**WEST SUSSEX COUNTY COUNCIL
STRATEGIC PLANNING CONSULTATION**

SUBJECT: BN/19/16/PL - Demolition of vacant office building & erection of 7 No. dwellings with associated garaging & landscaping. This application is a Departure from the Development Plan.

Land at Pollards Nursery, Lake Lane, Barnham, West Sussex, PO22 0AF

DRAWING
**Oxford+
Elevations**

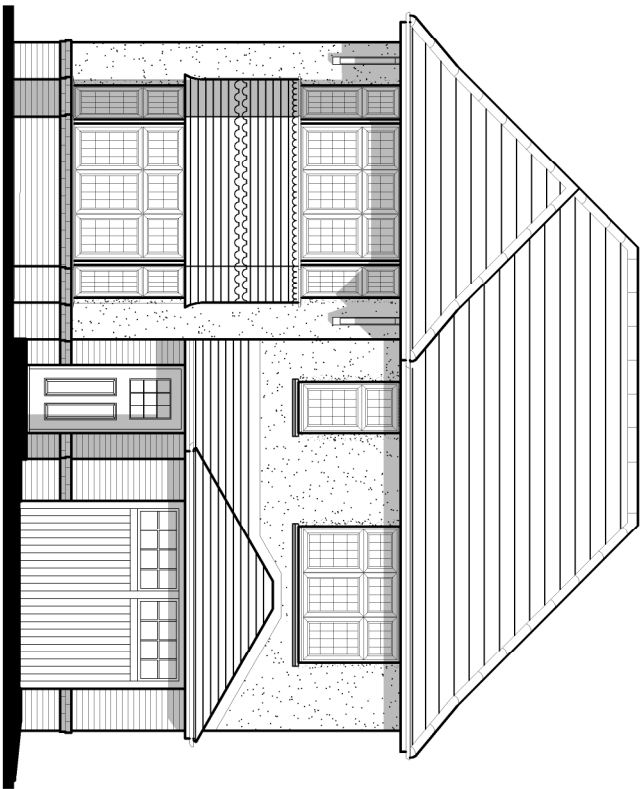
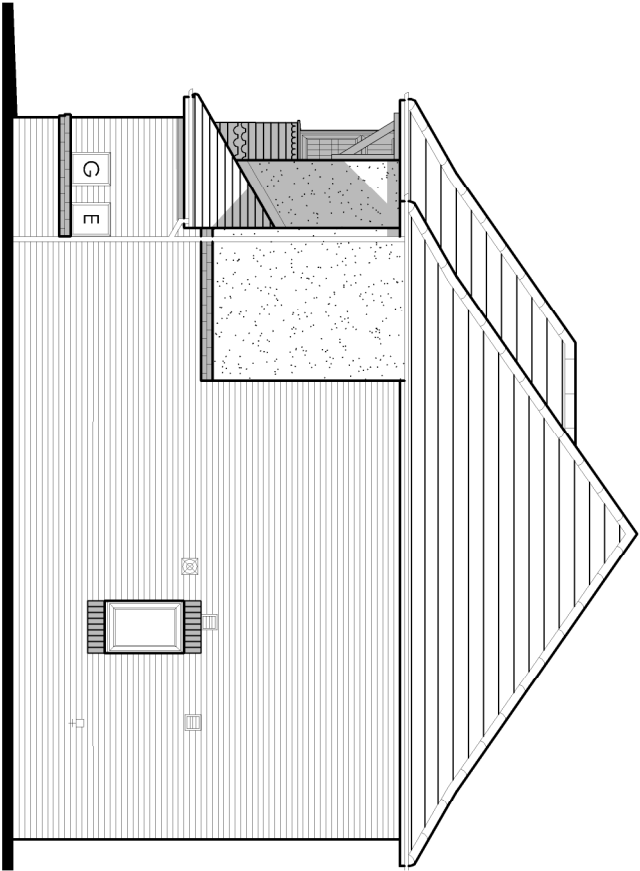
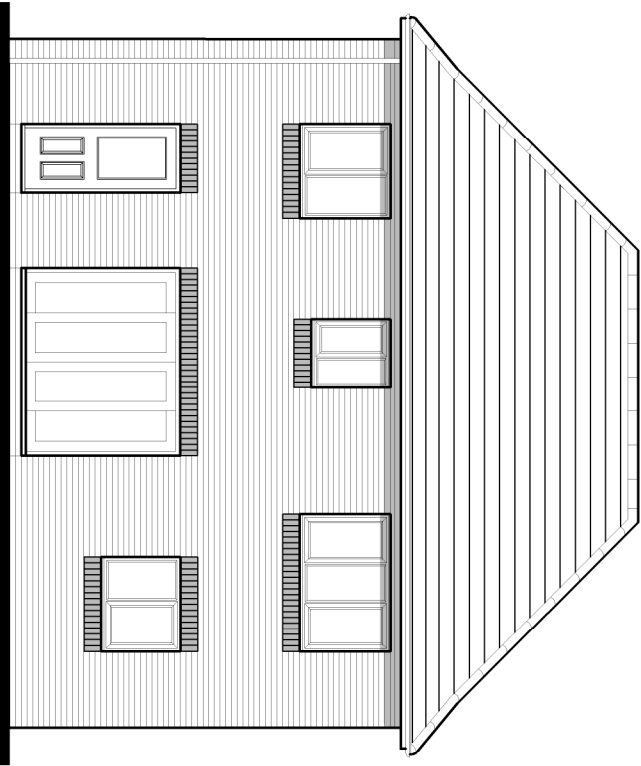
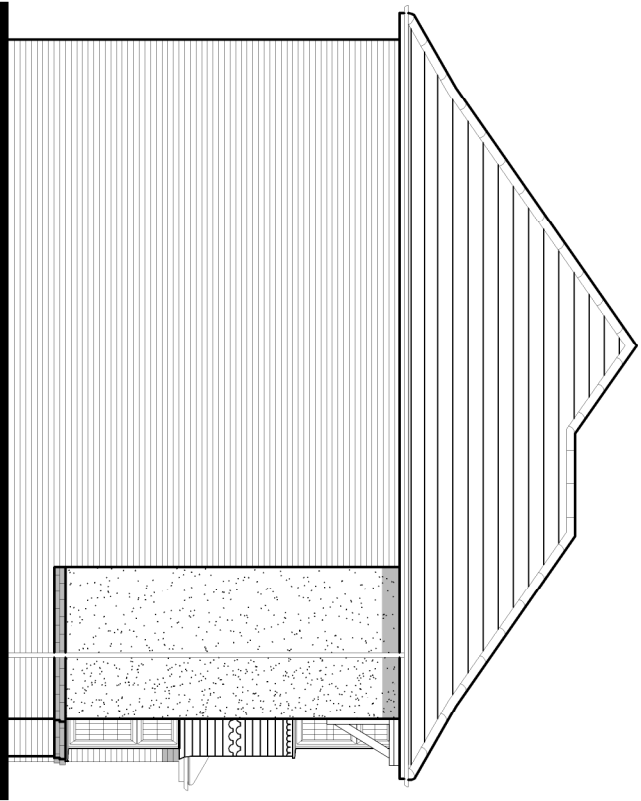
Adequate parking for each dwelling has been shown and a layby for visitor parking. The LHA would highlight that the parking arrangement for the first dwelling on the northern side of the access road is not ideal. Occupiers would have to reverse into or out of the parking bays; as such vehicles leaving the site coming round the bend in the access road may not see this occurring or have time to stop, possibly causing a

collision. It is considered that vehicle speeds would be low; however the LHA would advise that the parking layout be reconsidered for this dwelling.

The LHA would have no objections to this application; the LHA would ask that the applicant considers the parking arrangement for plot 1. The following conditions and informative should be applied.
